Subject: Re: FW: BR/236/18/L - Esmonde House, Flat 3

I am e-mailing regarding our earlier telephone call today re: BR/236/18/L - Esmonde House, Flat 3. The Conservation Officer's comments are as attached and of note are the following comments:

PROPOSED 'CONSERVATION TYPE' ROOF WINDOW, AND
110mm Ø PIPE FOR STORM WATER

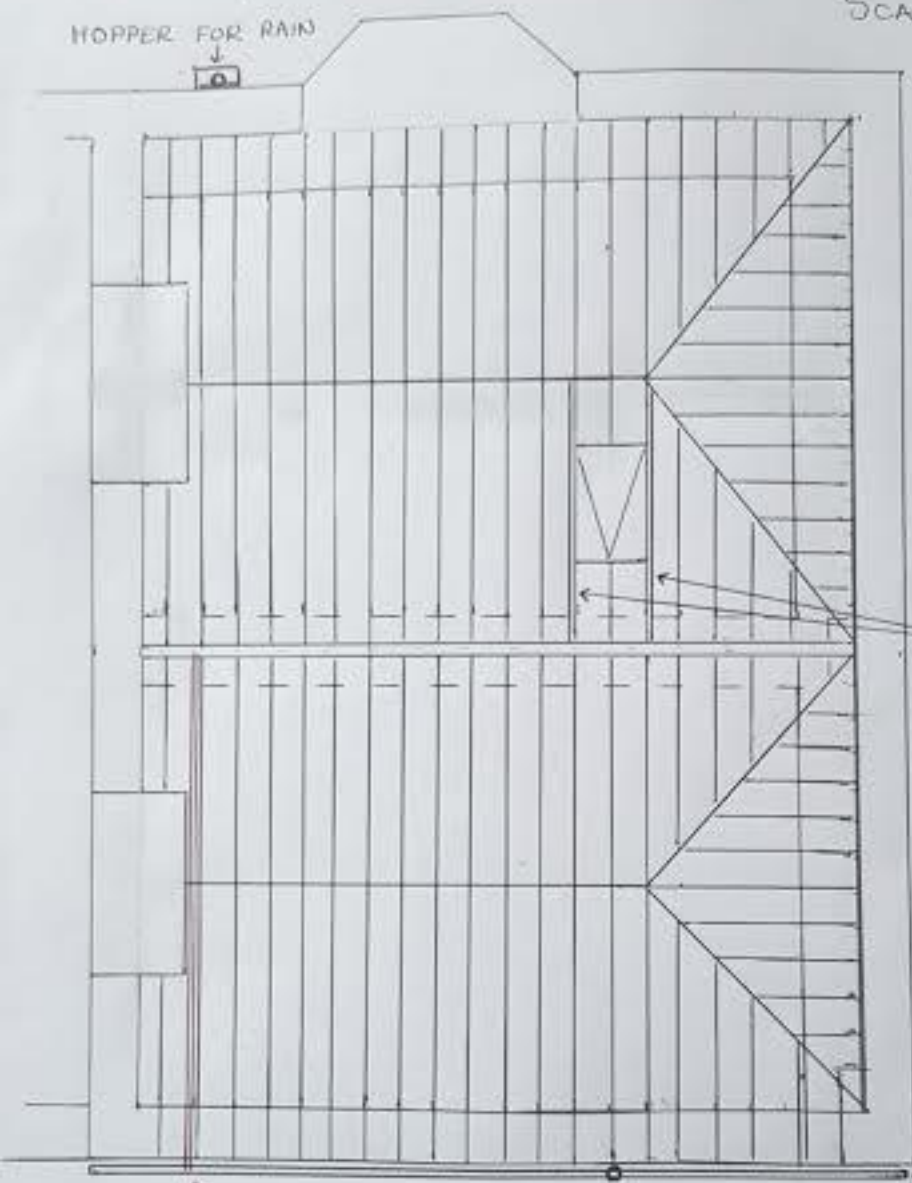
I also confirm the roof window will be of "conservation" style / standard... I would just like to confirm that this may be double glazed,??? as it is on the roof in hidden valley and will not be in sight.

SECOND FLOOR

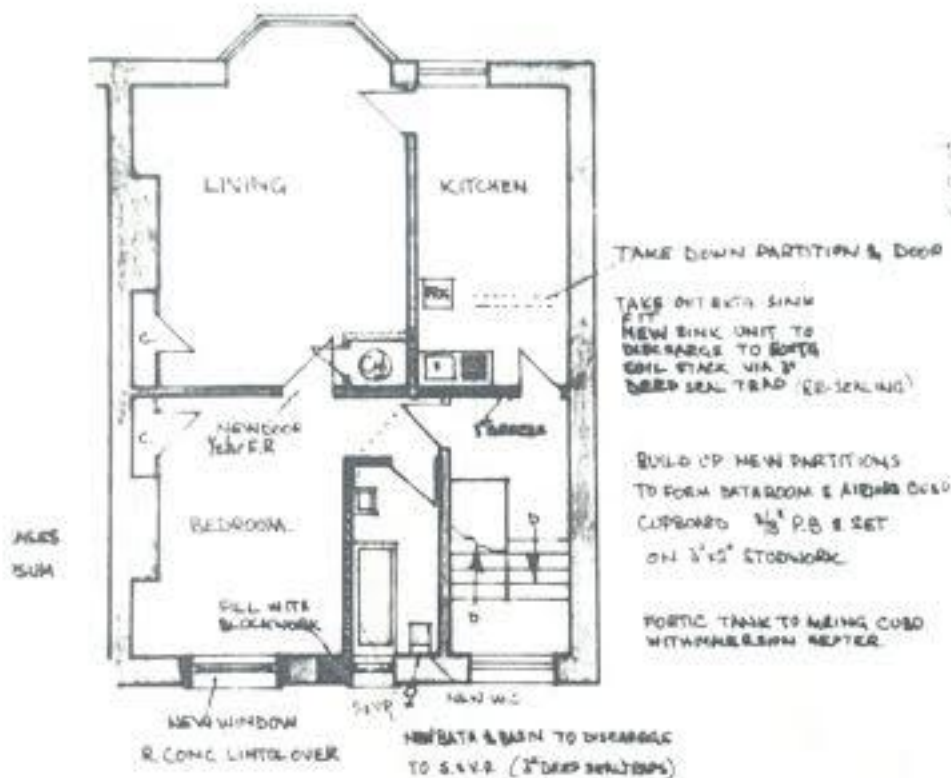
'The replacement of the windows identified on the plan is considered to be acceptable; as they appear to be in a poor state of repair. However, I note that reference is made to upvc double

glazing on the proposed floor plans. Such a window type is not supported. All of the windows should be constructed in wood, and be single glazed.

Confirmation will need to be provided in order to ensure that the windows are to be wooden, and single glazed. The windows must also be the same colour as present.'

Additionally, while the plans state that the windows are to be replaced no details of the windows appear to have been provided regarding their design. It appears that no elevation plans and/or annotated photos have been provided detailing the windows as proposed and as existing.

I confirm I am in agreement to install wooden single glazed, standard / traditional sash windows where stated and to match front and painted white (one window to front of property - top floor above black coloured front door in picture attached, and the bedroom and bathroom windows to the rear).

The windows will have centre bars in the glass, as seen in existing front window. However, I would assume the narrow bathroom window would be better without a centre bar, if agreed.
